WEST SUSSEX COUNTY COUNCIL CONSULTATION

TO:	Arun District Council FAO: Anita Gardner
FROM:	WSCC - Highways Authority
DATE:	2 February 2022
LOCATION:	Land West Of Yapton Lane Walberton
SUBJECT:	WA/2/22/OUT Outline planning application with all matters reserved, other than means of access, for the construction of up to 48 dwellings (30% affordable homes) and dental/doctors' surgery (Use Class E (e)). This application may affect the setting of a listed building & may affect the Walberton Village Conservation Area.
DATE OF SITE VISIT:	n/a
RECOMMENDATION:	More Information
S106 CONTRIBUTION TOTAL:	n/a

Figure 04: illustrative masterplan

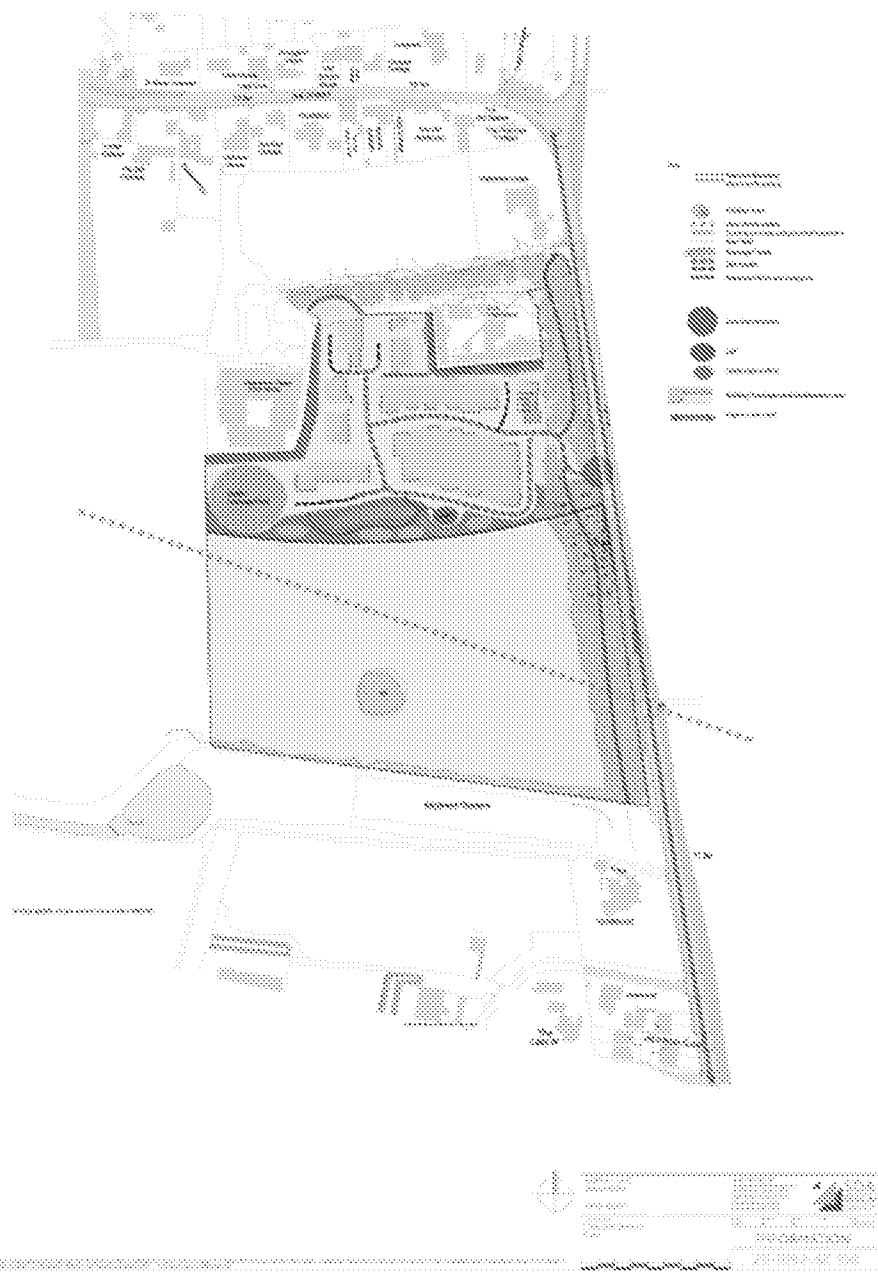
No comments are offered in respects of the layout at this stage. The plan submitted is very much indicative in nature with very limited information.

The layout plan indicates a potential doctors/dentist surgery. There is no consideration of this within the TS nor is it referenced within the application description. This is understood to fall outside of the current application. No assessment has been given to the potential transport impacts that may result from this.

Figure 3: Public Rights of Way

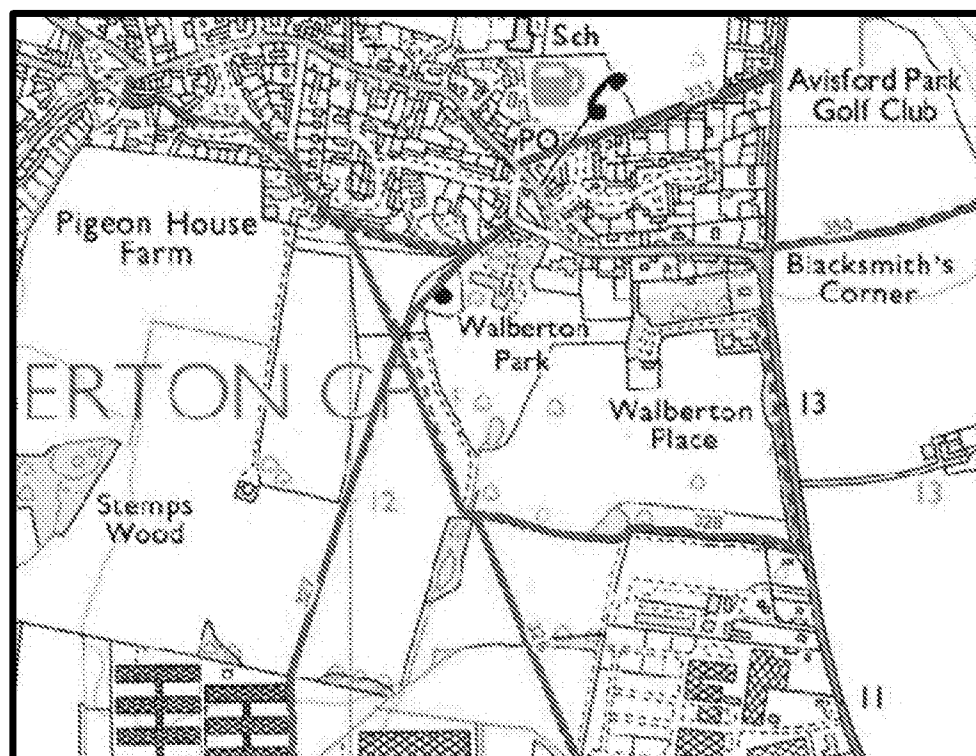
For the purposes of accessing Walberton, the existing permissive footpath P23 is to be upgraded. This footpath currently runs through a wooded area. Whilst there's no in principle issue with the footpath being upgraded, given the relative importance of this route in providing access to Walberton there should be clarity at this stage as to what is intended in terms of upgrading works and that these works are then deliverable. It's vital that any works provide for a footpath that is usable all year round.

In order for cyclists to join The Street, it would be highly desirable to also upgrade the permissive footpath, or at least the section north of the proposed vehicular access, to accommodate cyclists. Such an arrangement would still require cyclists to use a short section of Yapton Lane when travelling north. The applicant should demonstrate in principle that such works are achievable although the exact details can still be secured via condition.
